From: Tybie House [REDACTED]
Sent: 27 June 2026 18:41
To: Neil Crowther
Cc: Karl Roberts
Subject: A/44/26/PL
Attachments: Revised Drainage Review.pdf

Analysis of the revised drainage information

Point-by-point comments on Odyssey response dated 16 June 2026

Drawing Title
**DRAINAGE
CONSTRUCTION DETAILS (SHEET 1)**

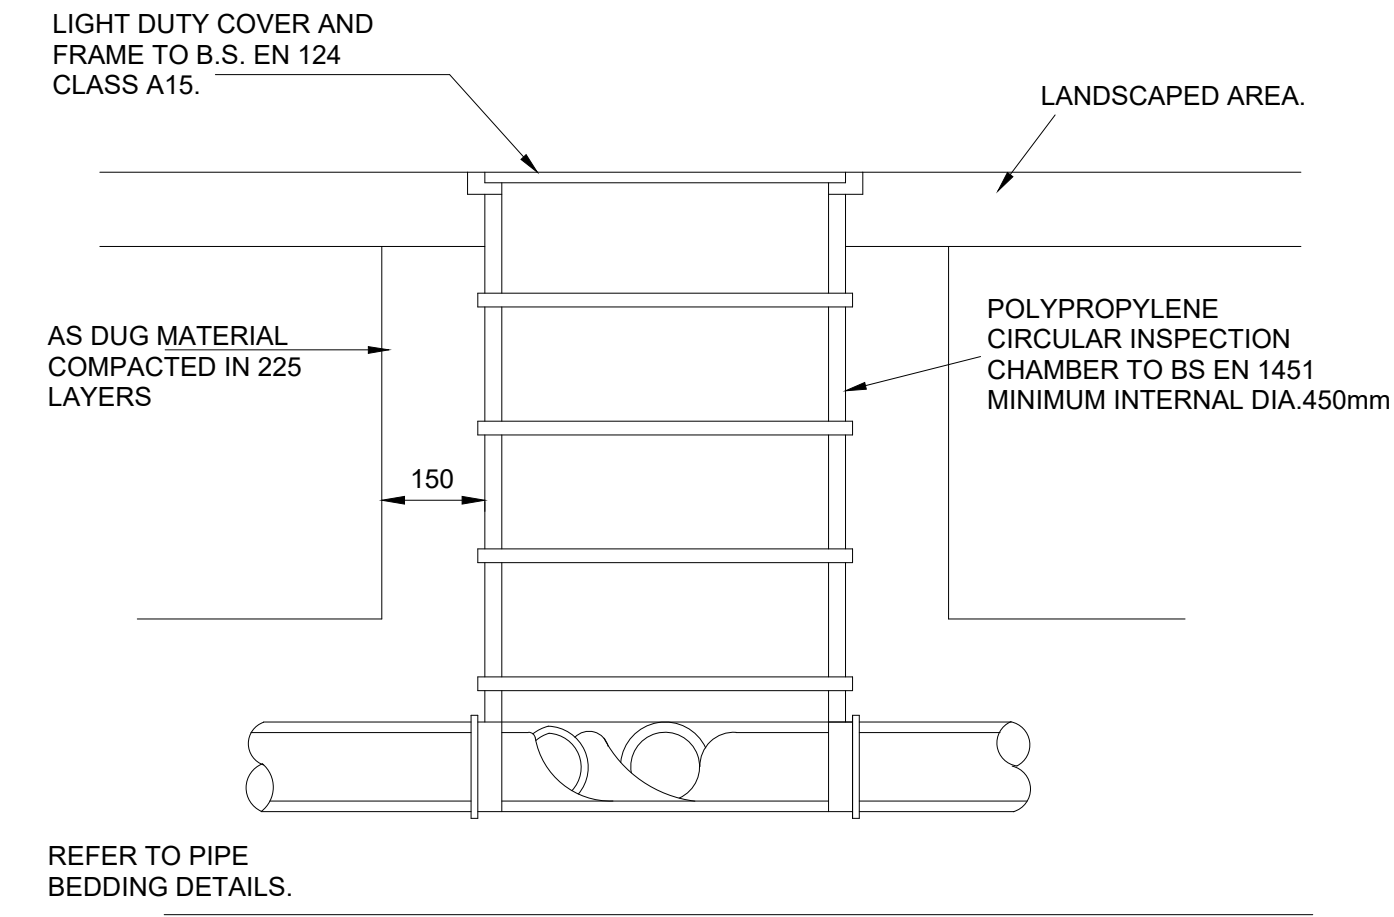
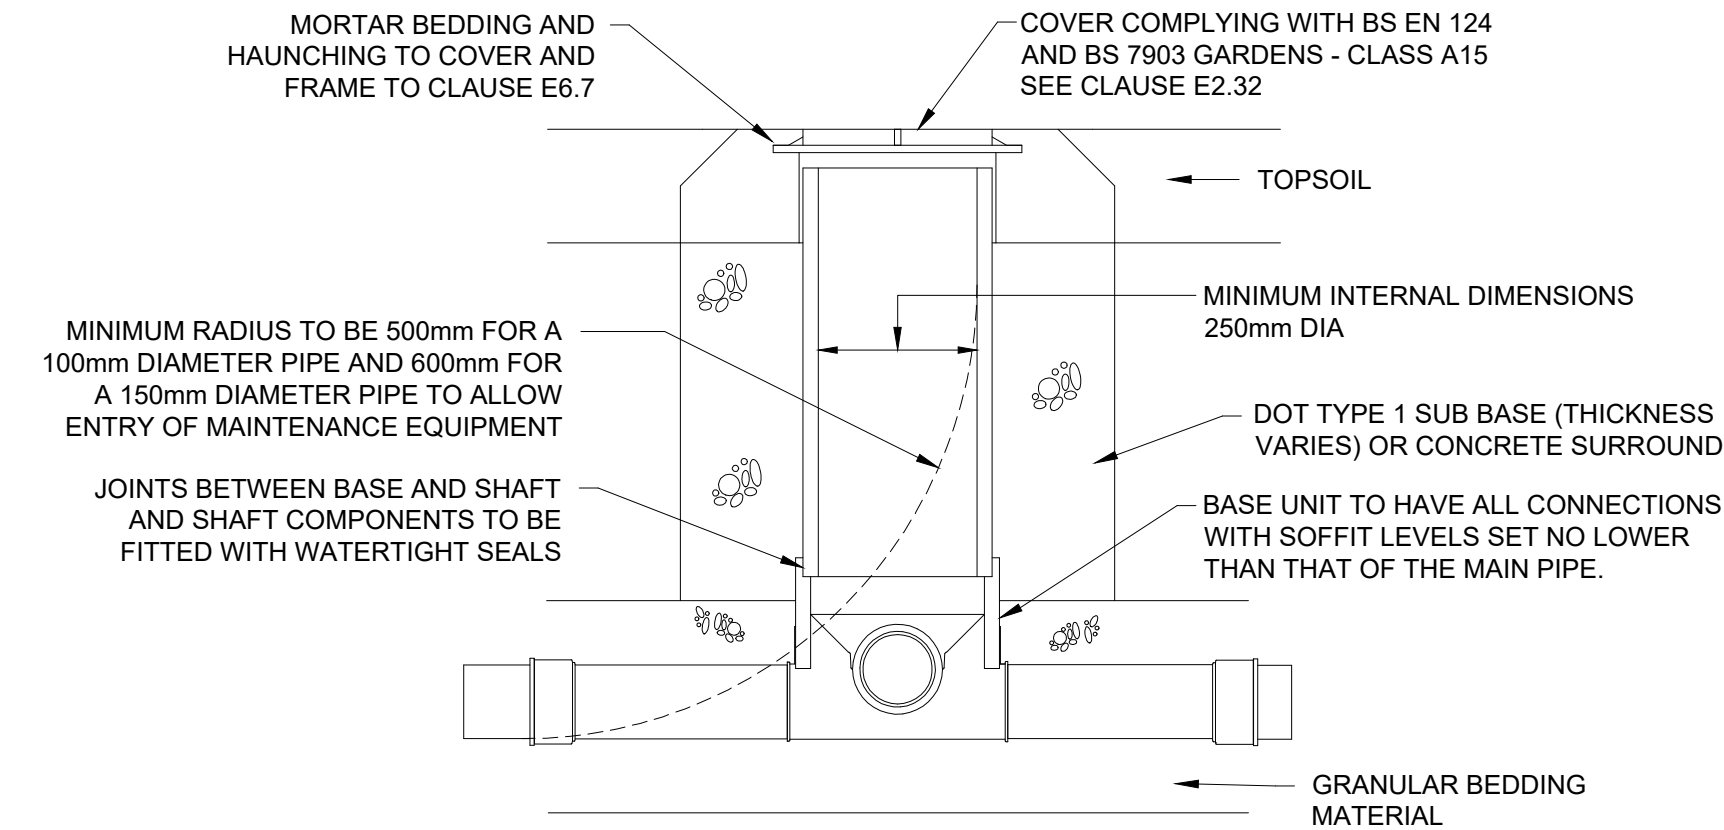
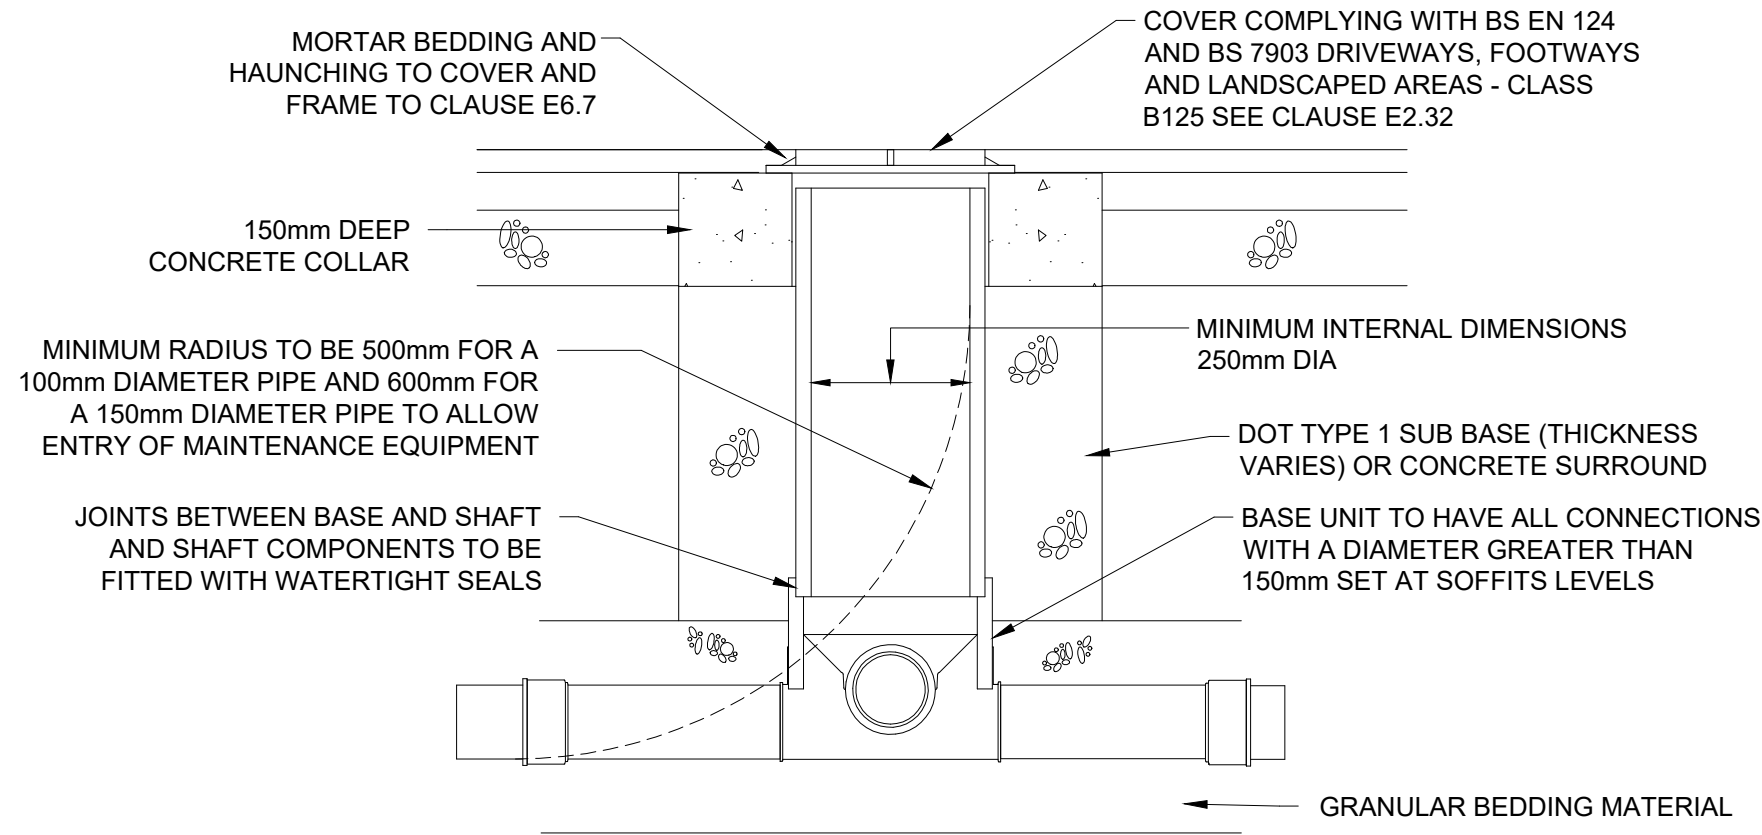
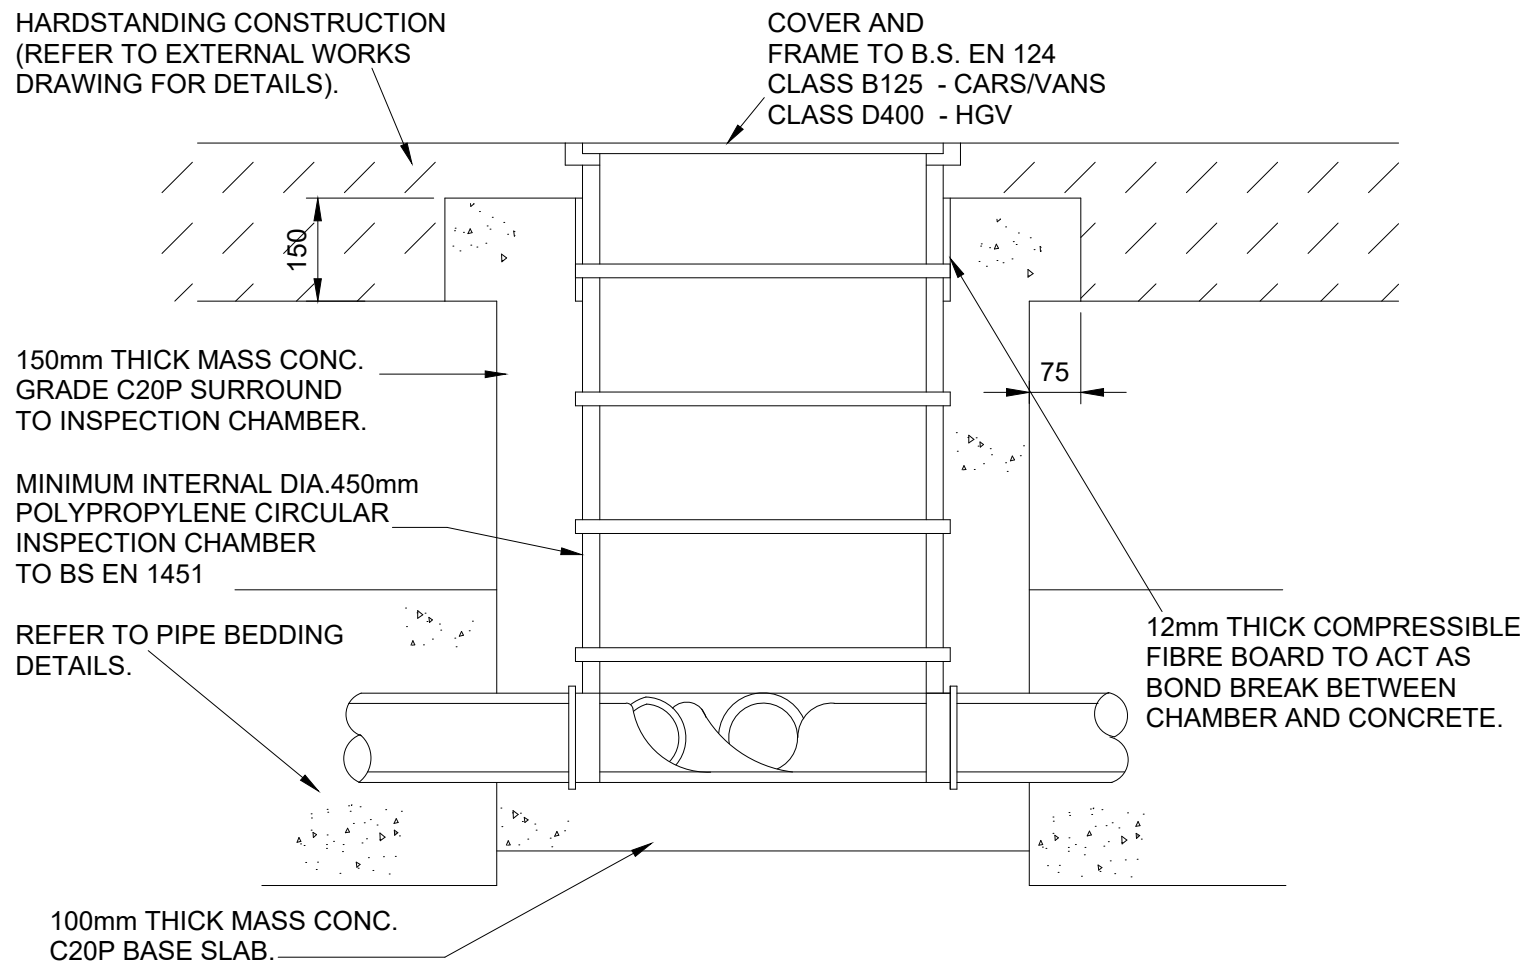
The problem with this design which appears to have been overlooked, is that the construction detail of SA1 in drawing number 21-254-502 shows an inspection chamber at each end. This results in a loss of infiltration area and storage volume. Given the stated dimensions of the chambers, internal diameter of 1200mm and minimum of 150mm concrete surround, both the area and the volume need reducing by the space taken up by the chambers. Allowing conservatively for 80 mm chamber wall thickness gives an effective external diameter of approximately 1.66 m as a minimum.

Consequently, the infiltration area needs reducing by 4.328 m² and the storage volume by 2.662 m³.

In short, the calculations ought to be based on an area of 842.172 m² and the storage of SA1 ought to be 517.936 m³.

**PERMEABLE PAVING
CROSS SECTIONS**

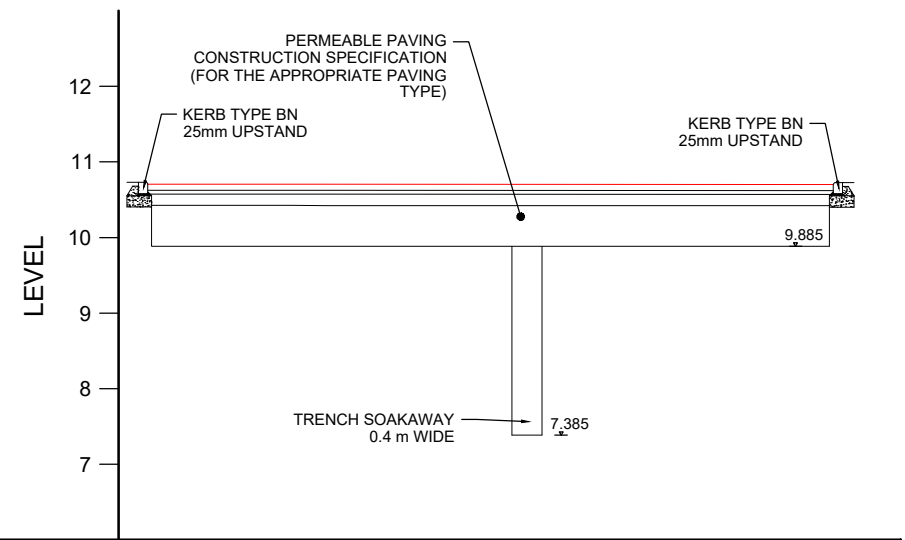
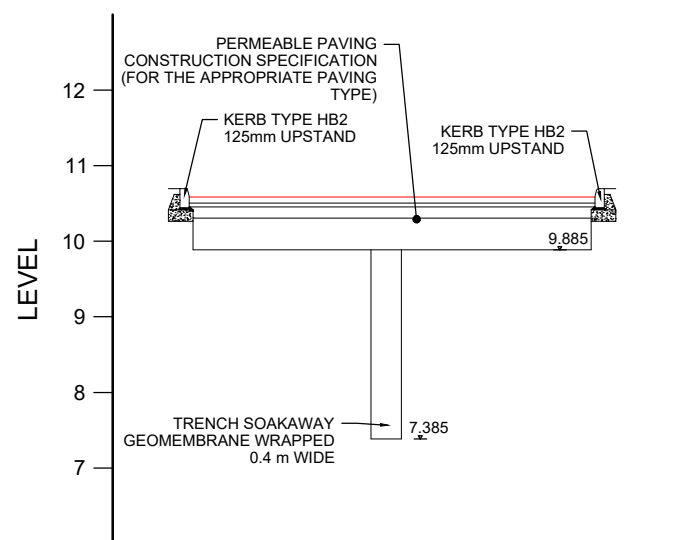
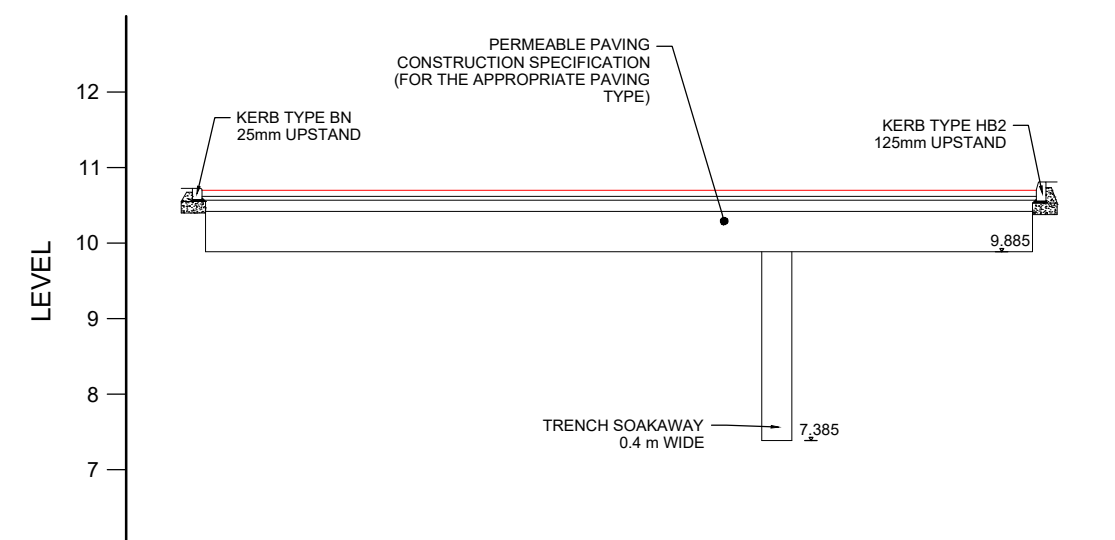
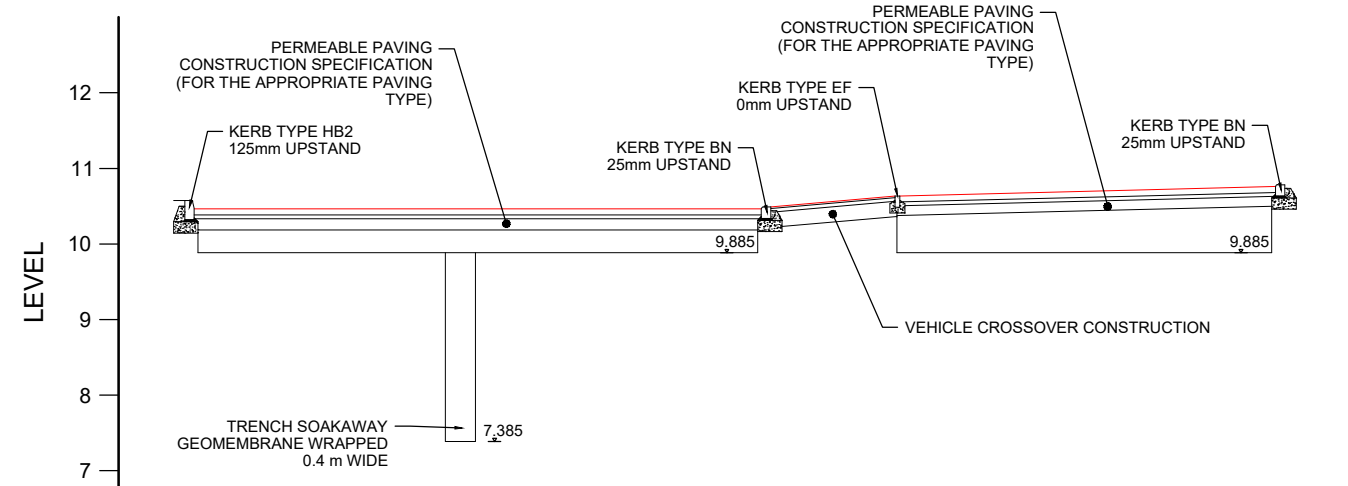
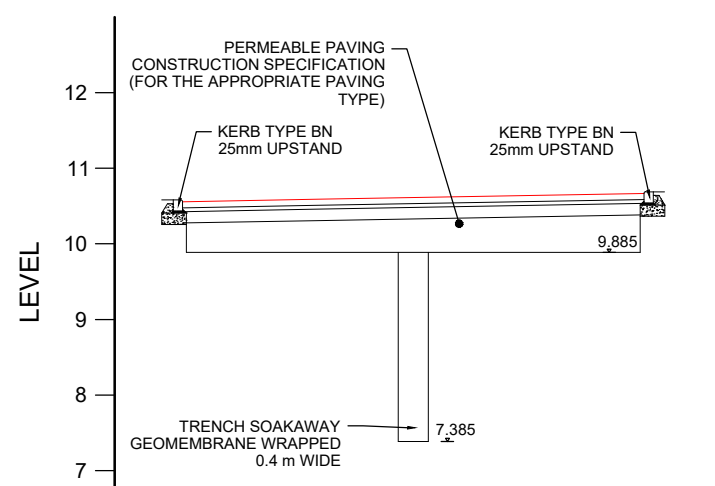
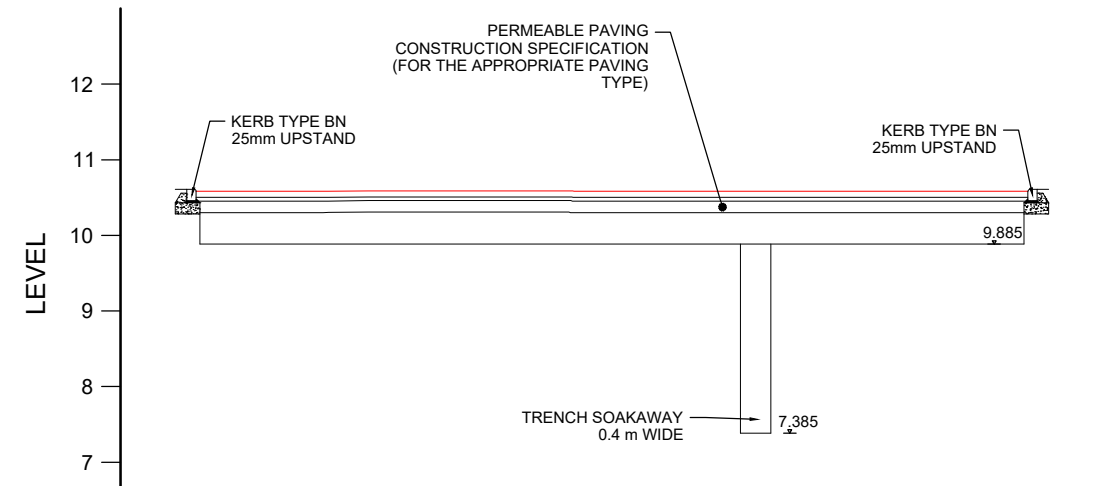
Permeable paving appears no longer to be credited as an infiltration feature, but it is still being used within the updated hydraulic arrangement as linked storage and conveyance. That distinction matters. If permeable paving is not being counted for infiltration, it cannot be used to support the infiltration adequacy of the scheme. If it is being used for storage / conveyance, then its construction, levels, connectivity, maintenance access, silt management and long-term performance remain material.

This is particularly important given previous concerns about maintainability. A feature ought not to be treated as irrelevant for infiltration purposes while simultaneously being used as part of the linked storage and overflow mechanism without clear evidence that it is properly constructed, maintainable and hydraulically connected. If the reason for discounting permeable paving as an infiltration feature is connected with maintenance or long-term performance, the applicant ought to explain why the storage volume within that same feature can nevertheless be relied upon for the lifetime of the development, given that without adequate maintenance its effective storage volume may reduce through siltation, blockage or loss of hydraulic connectivity. Without that assurance, it appears that permeable paving is being excluded where it is inconvenient to rely upon it as infiltration, but included where its storage volume is needed to support the hydraulic model.

Odyssey's own 480-minute critical run uses 217.224 m³ of storage outside SA1. However, that figure includes 159.484 m³ within the permeable paving. If permeable paving cannot be relied upon as dependable long-term storage because of unresolved maintenance, siltation, blockage or hydraulic-connectivity concerns, then the available outside-SA1 storage reduces to approximately:

This sensitivity check is significant. It shows that, if permeable paving is not treated as dependable long-term storage, the FoS 1.5 case no longer merely appears borderline; it fails the 6-hour, 12-hour and 24-hour storm durations by substantial margins. The FoS 5.0 sense check is worse again.
